**RE: Springhill Suites
Grading and Drainage Plan
Engineer's Stamp Date – 9-22-16
Hydrology File: F17D006B**

Based upon the information provided in your submittal received 9-22-2016, the above referenced Grading and Drainage Plan is approved for ESC Building Permit/Grading Permit and approved for Site Plan for Building Permit.

We have revised the plans to address your email comments from 3/11/2016. The following are your comments and our responses as to how we addressed are shown in red. We have enclosed the corrected grading plan.

ENGINEER'S SEAL  9/22/16 2/16/16 DAVID SOULE P.E. #14522	4875 Pan American West Freeway NE  GRADING AND DRAINAGE PLAN   Rio Grande Engineering 1806 CENTRAL AVENUE SE SUITE 201 ALBUQUERQUE, NM 87106 (505) 872-0999	DRAWN BY WCWJ
		DATE 2-01-16  21526-LAYOUT-10-21-15  SHEET # C001  JOB # 21526

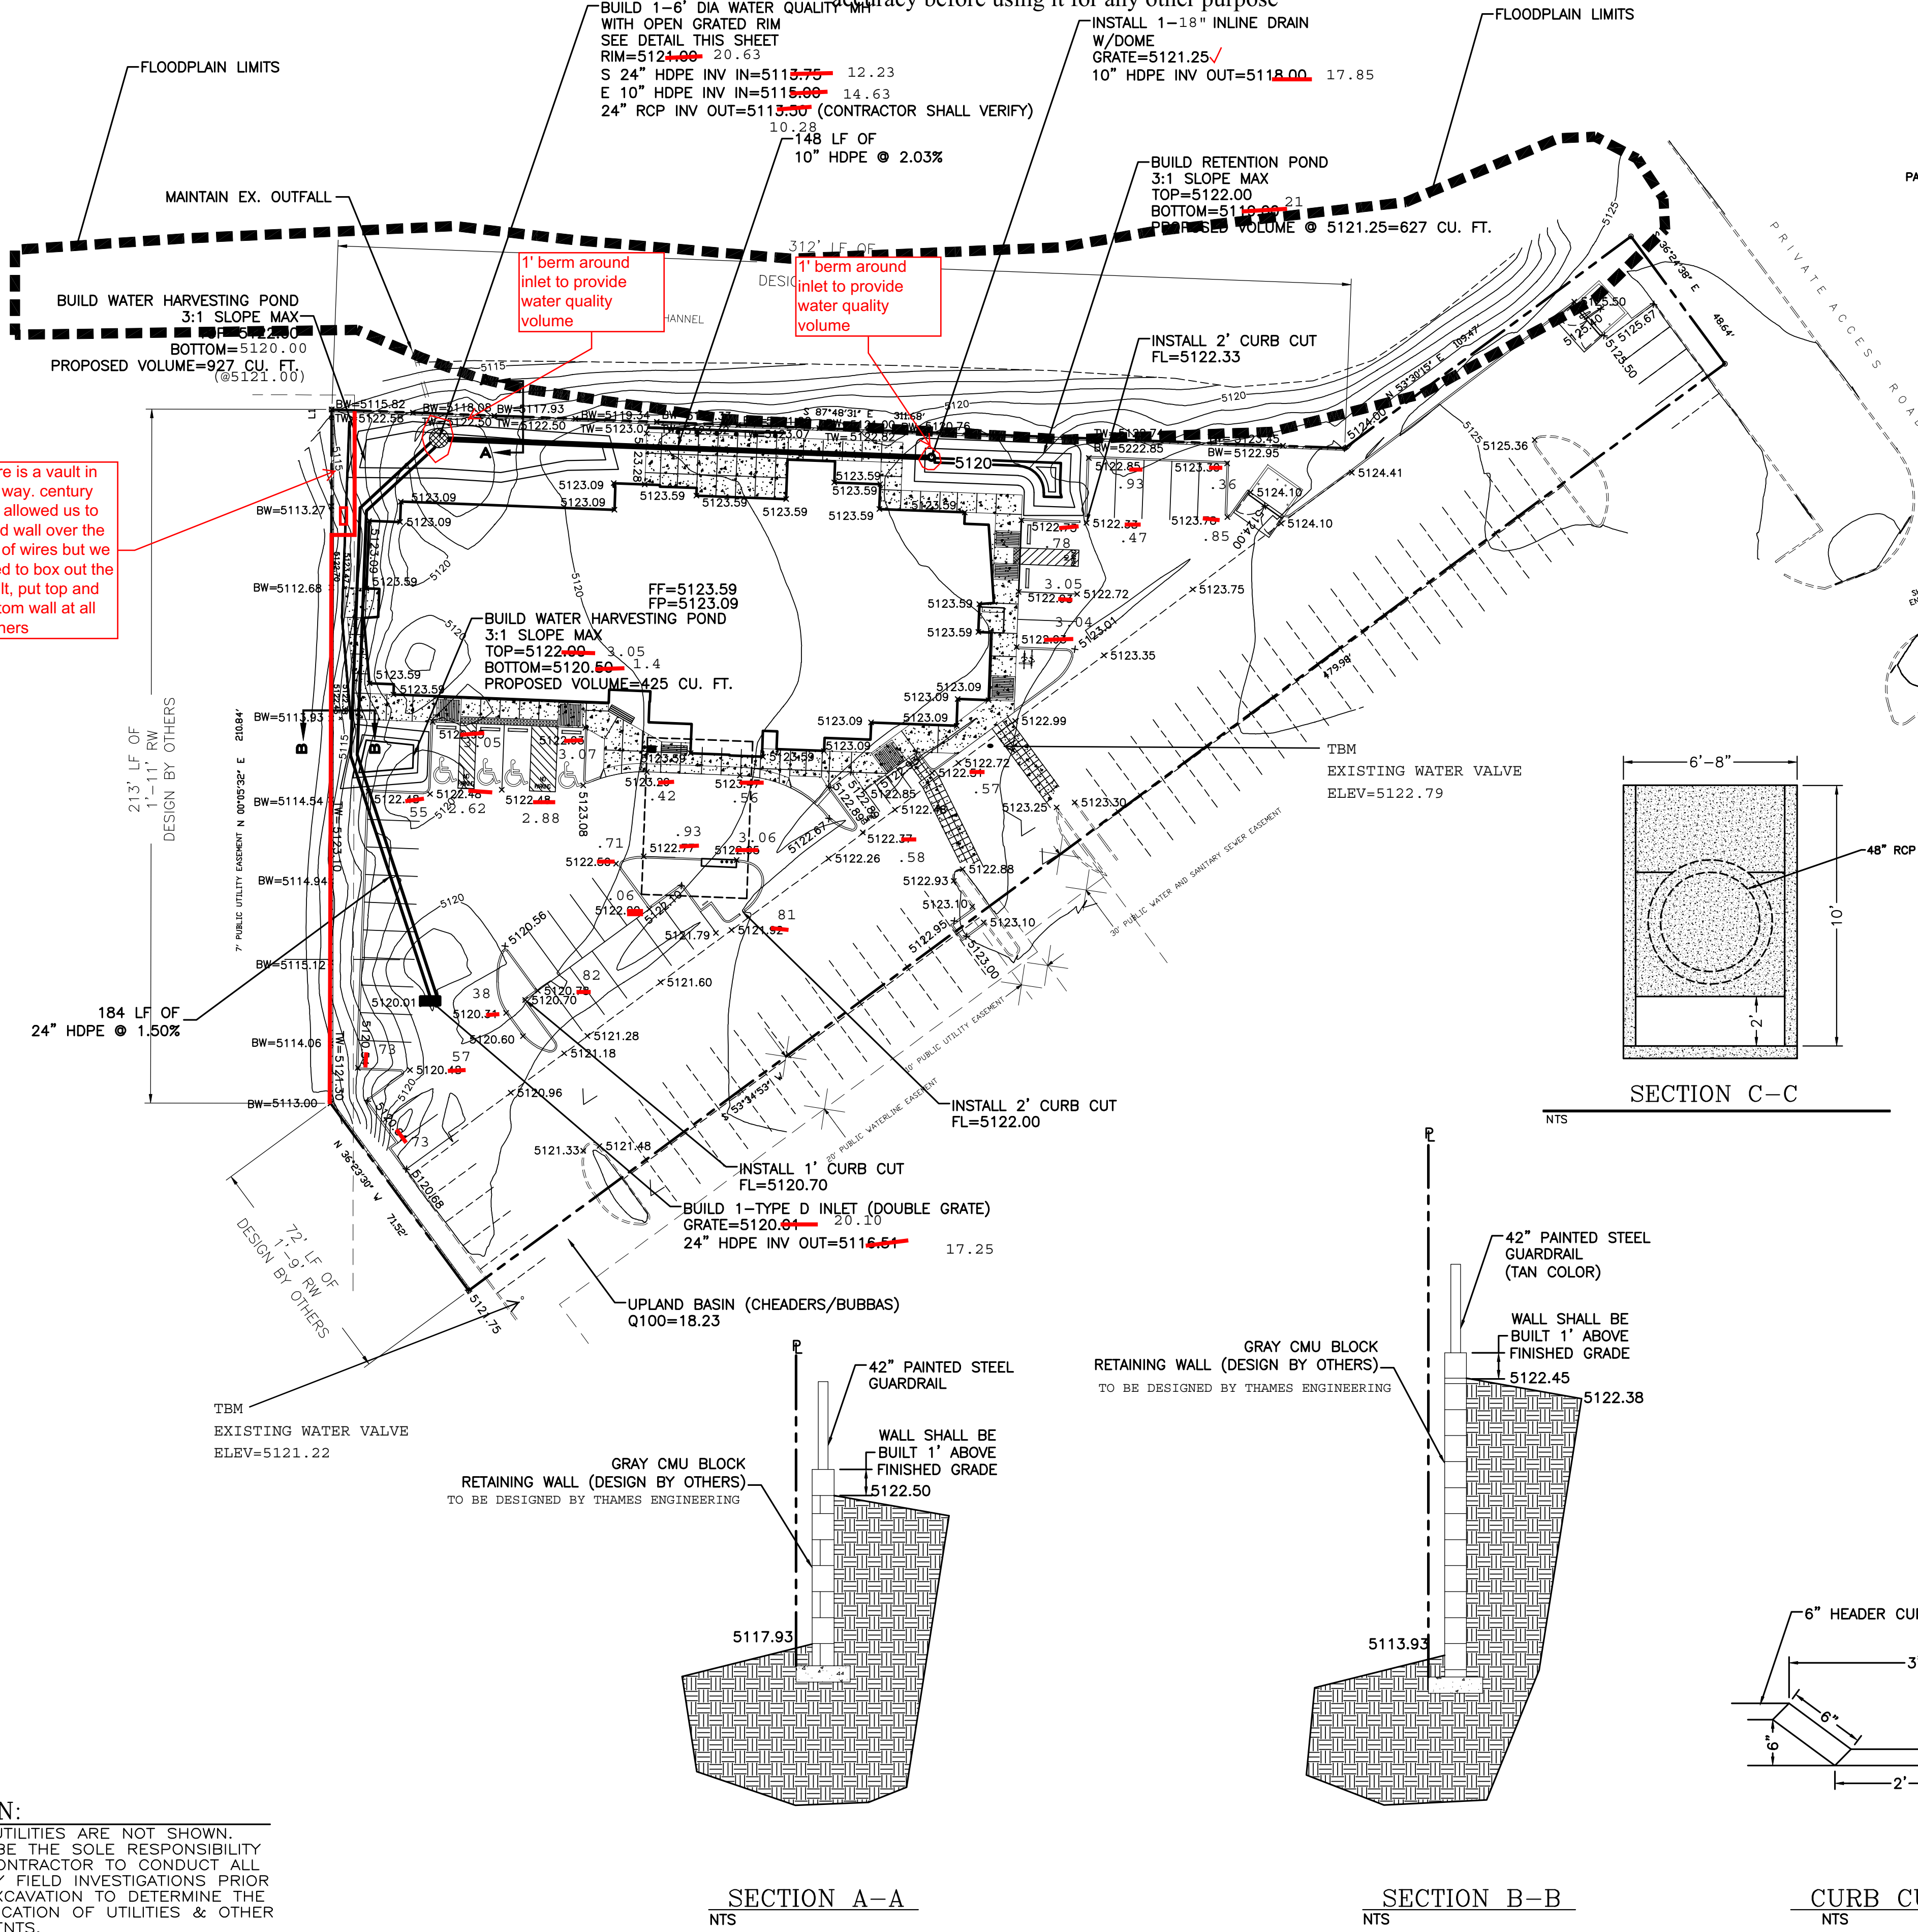
1. An Erosion and Sediment Control Plan is approved by the City's Storm Water Quality Engineer.
 - a. Please ensure that the ESC Plan conveys to the Contractor/Builder, that no discharge is allowed during construction onto the property/easement to the west owned by PNM.
An ESC has been prepared and discharge to adjacent properties are prevented by BMP's

2. A water quality manhole detail was added to this re-submittal, but it still appears to have elevation and sizing information from another project.
We have corrected this information

- a. The baffle (which can be a pre-manufactured attachment), needs to have an anti-siphon opening at the top.
We have added 2- 1" holes at the top edge to provide to serve as an anti-siphon

3. As previously discussed, a floodplain permit will be needed prior to pulling an ESC/Grading Permit.
We have submitted this
4. Include benchmark information, unless it is to be shown on a separate sheet of the construction set.
We have Identified the ACS monument utilize in the notes section. We have identified two separate TBM's on the site as well
